Consultation Response from KC, Highways Development Management
2023/93704 land northwest of, Urban Terrace, Denby Lane, Grange Moor, Huddersfield, WF4 4EB
Erection of 10 dwellings and associated works
Date Responded:07/11/2024
Responding Officer: Ryan Kinder
Responding Ref:K16-6/38

2023/93704 land northwest of, Urban Terrace, Denby Lane, Grange Moor

1 Proposed Site Layout

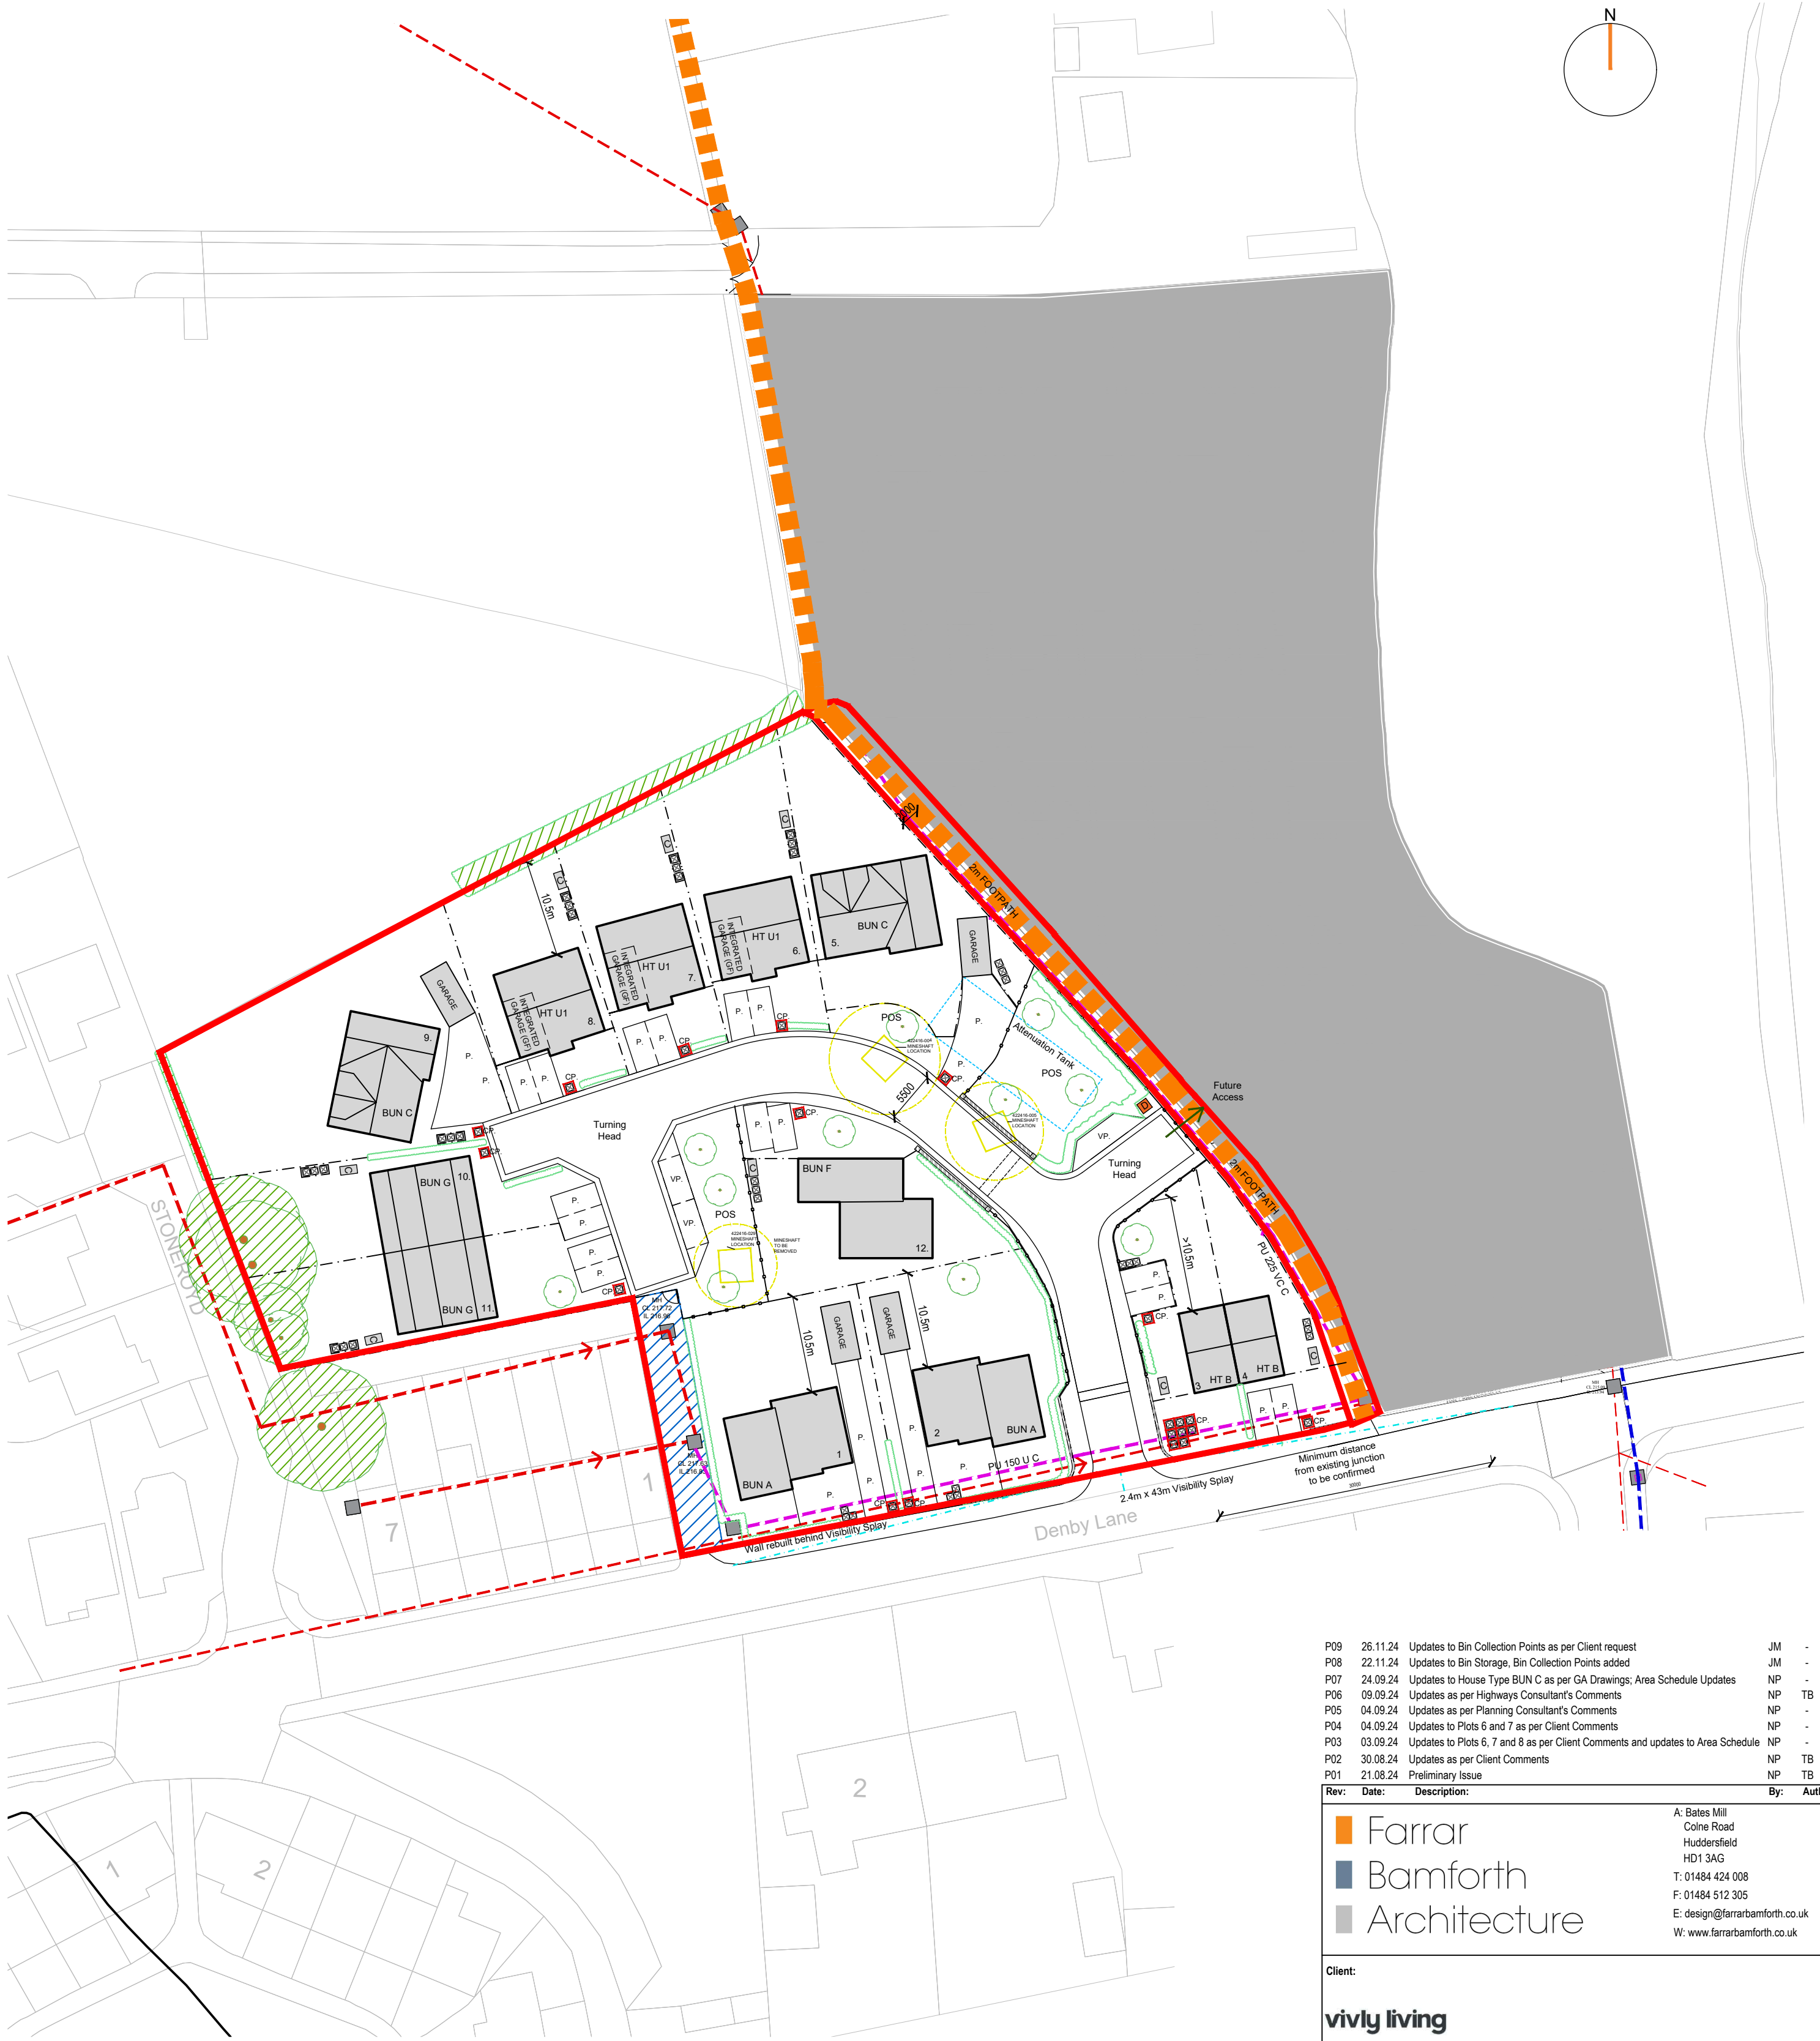
Clarification is sought on the intention of having the internal layout to be adopted by the Council, the proposed layout as it stands appears to be suitable for this, however if the internal layout is to remain private then a refuse vehicle will not be obliged to enter any of the site which is intended to remain unadopted. In addition a refuse collection point and turning for a refuse vehicle at that location will be required if not adjacent to Denby Lane.

A plan detailing the intended area for adoption or to remain private is requested, this 'Highways Area Plan' plan will form part of the approved planning documentation, should amendments be required in terms of the areas to be adopted etc if planning is approved then a section 73 application will be required to vary this. An example of the requirements of this plan can be obtained by contacting me direct.

A stage 1 safety audit in accordance with GG119 and designers response is requested for the

proposed development internal layout. A scoping brief will need to be submitted and agreed with the Councils Highway Safety audit team with any amendments required prior to or as a result of its undertaking.
